DRB Application No.: 03-01896 (P&F)	Project # 1002638
Project Name: BUENA VENTURA	EPC Application No.:
Agent: Surveys Southwest	Phone No.: 998-0303

SURVEYS SOUTHWEST, LTD agent(s) for KIET & NGA NGUYEN request(s) the above action(s) for all or a portion of Lot(s) 13, Block(s) 31, **BUENA VENTURA**, zoned R-1 residential zone, located on ALTEZ ST NE, between COPPER AVE. NE and ERBBE ST. NE containing approximately 1 acre(s). [REF: 03DRB-00714] (K-20) **PRELIMINARY PLAT WAS APPROVED WITH FINAL PLAT SIGN OFF DELEGATED TO PLANNING FOR REAL PROPERTY AND AMAFCA SIGNATURES.**

RE: Buena Ventura, Lot 13, Block 31/prelim & final

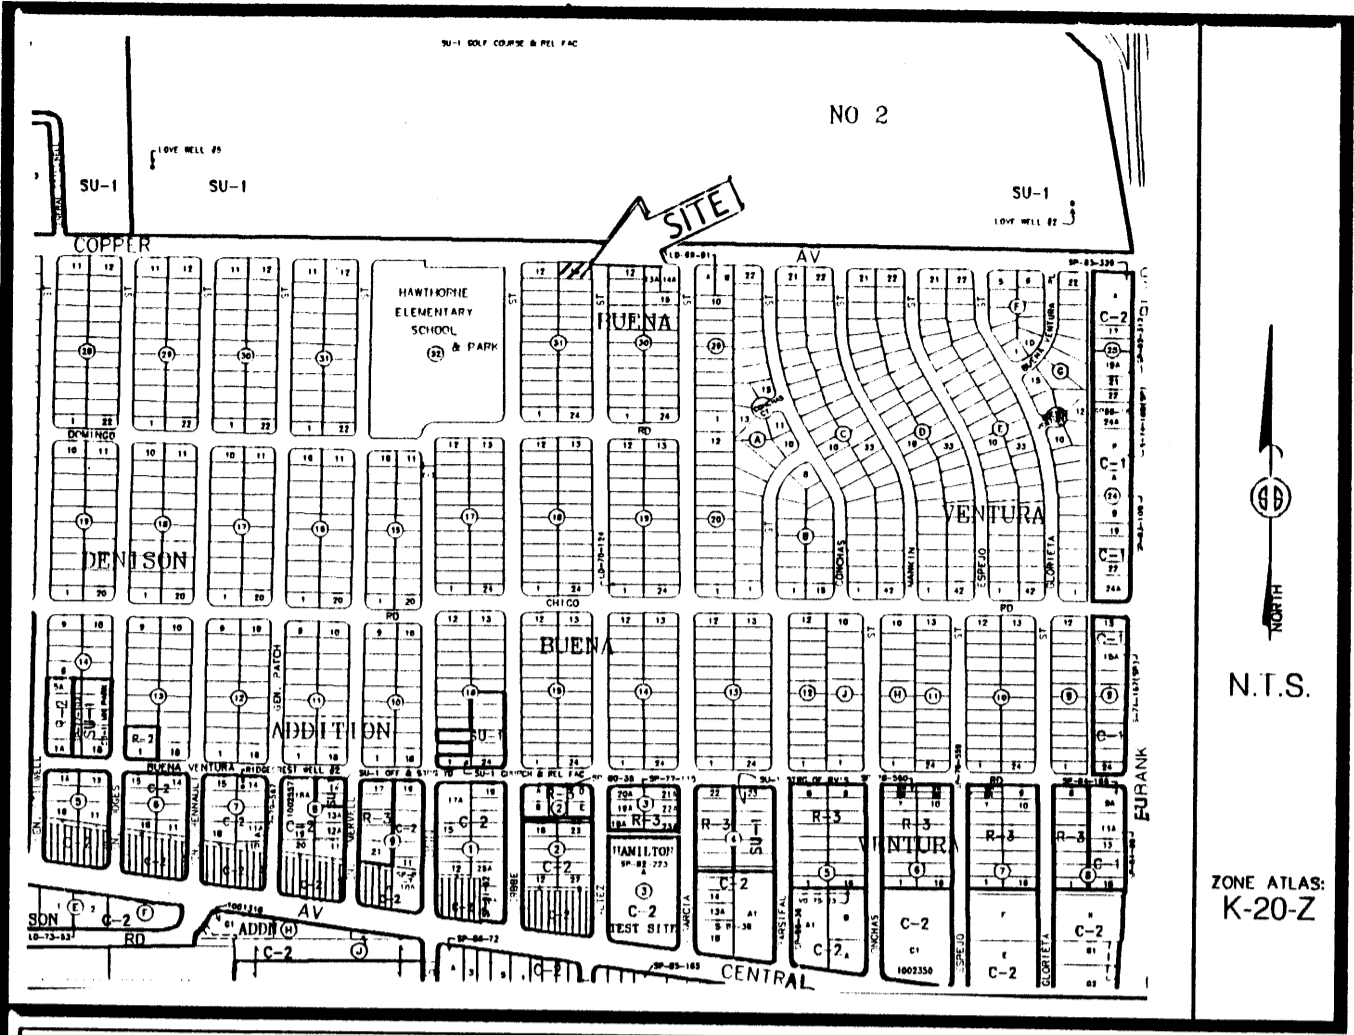
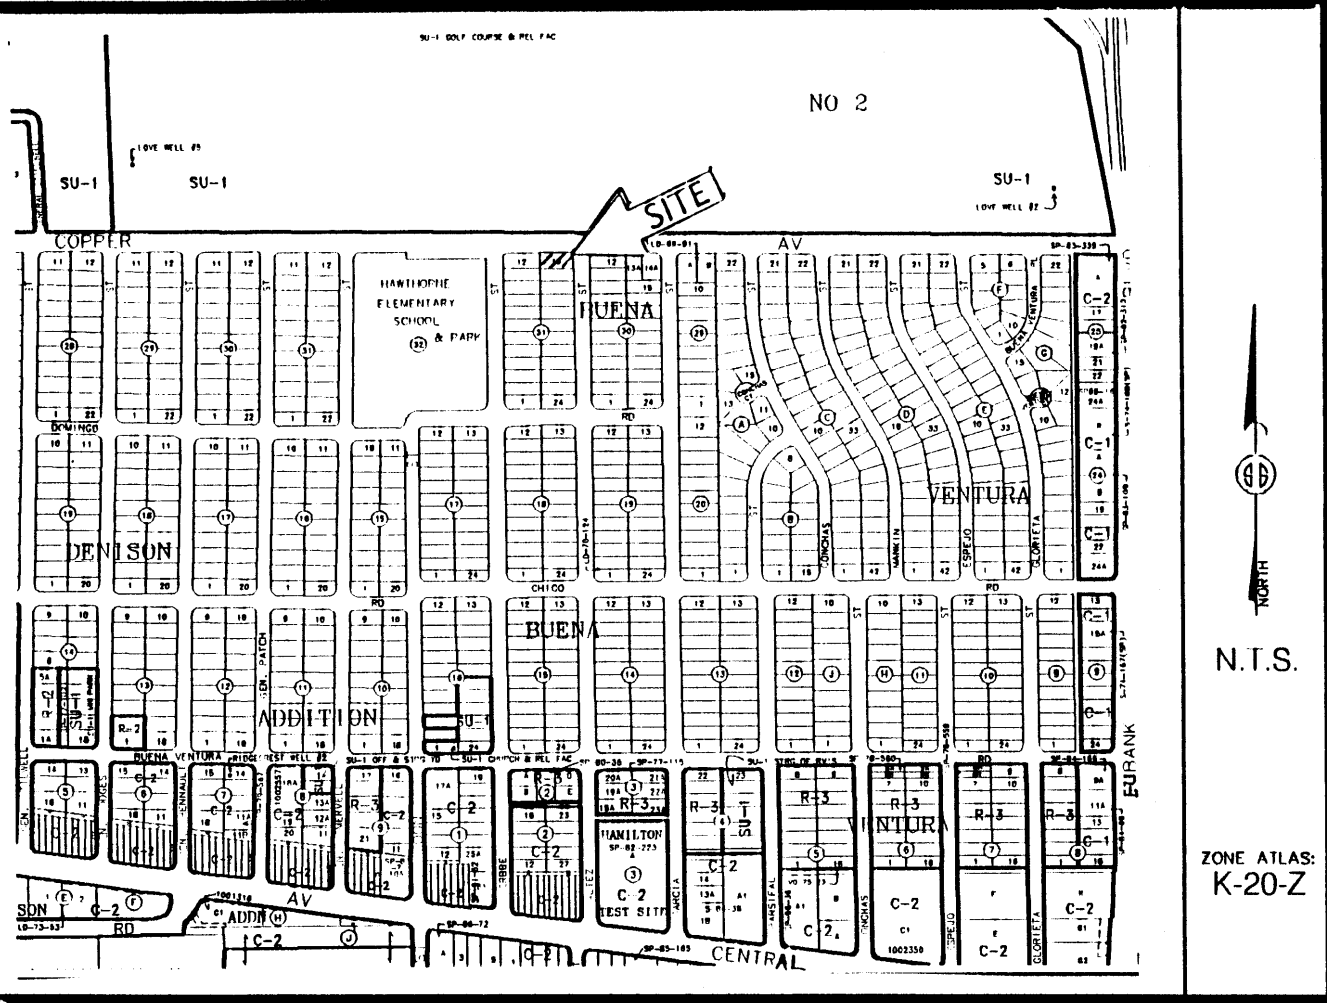
No.	Comment
(1)	IS THERE A 4' SIDEWALK ALONG COPPER & ALTEZ? WHERE IS THIS IN RELATION TO THE NEW PROPERTY LINE?
(2)	DUES COPPER AVE HAVE BIKE LANES?
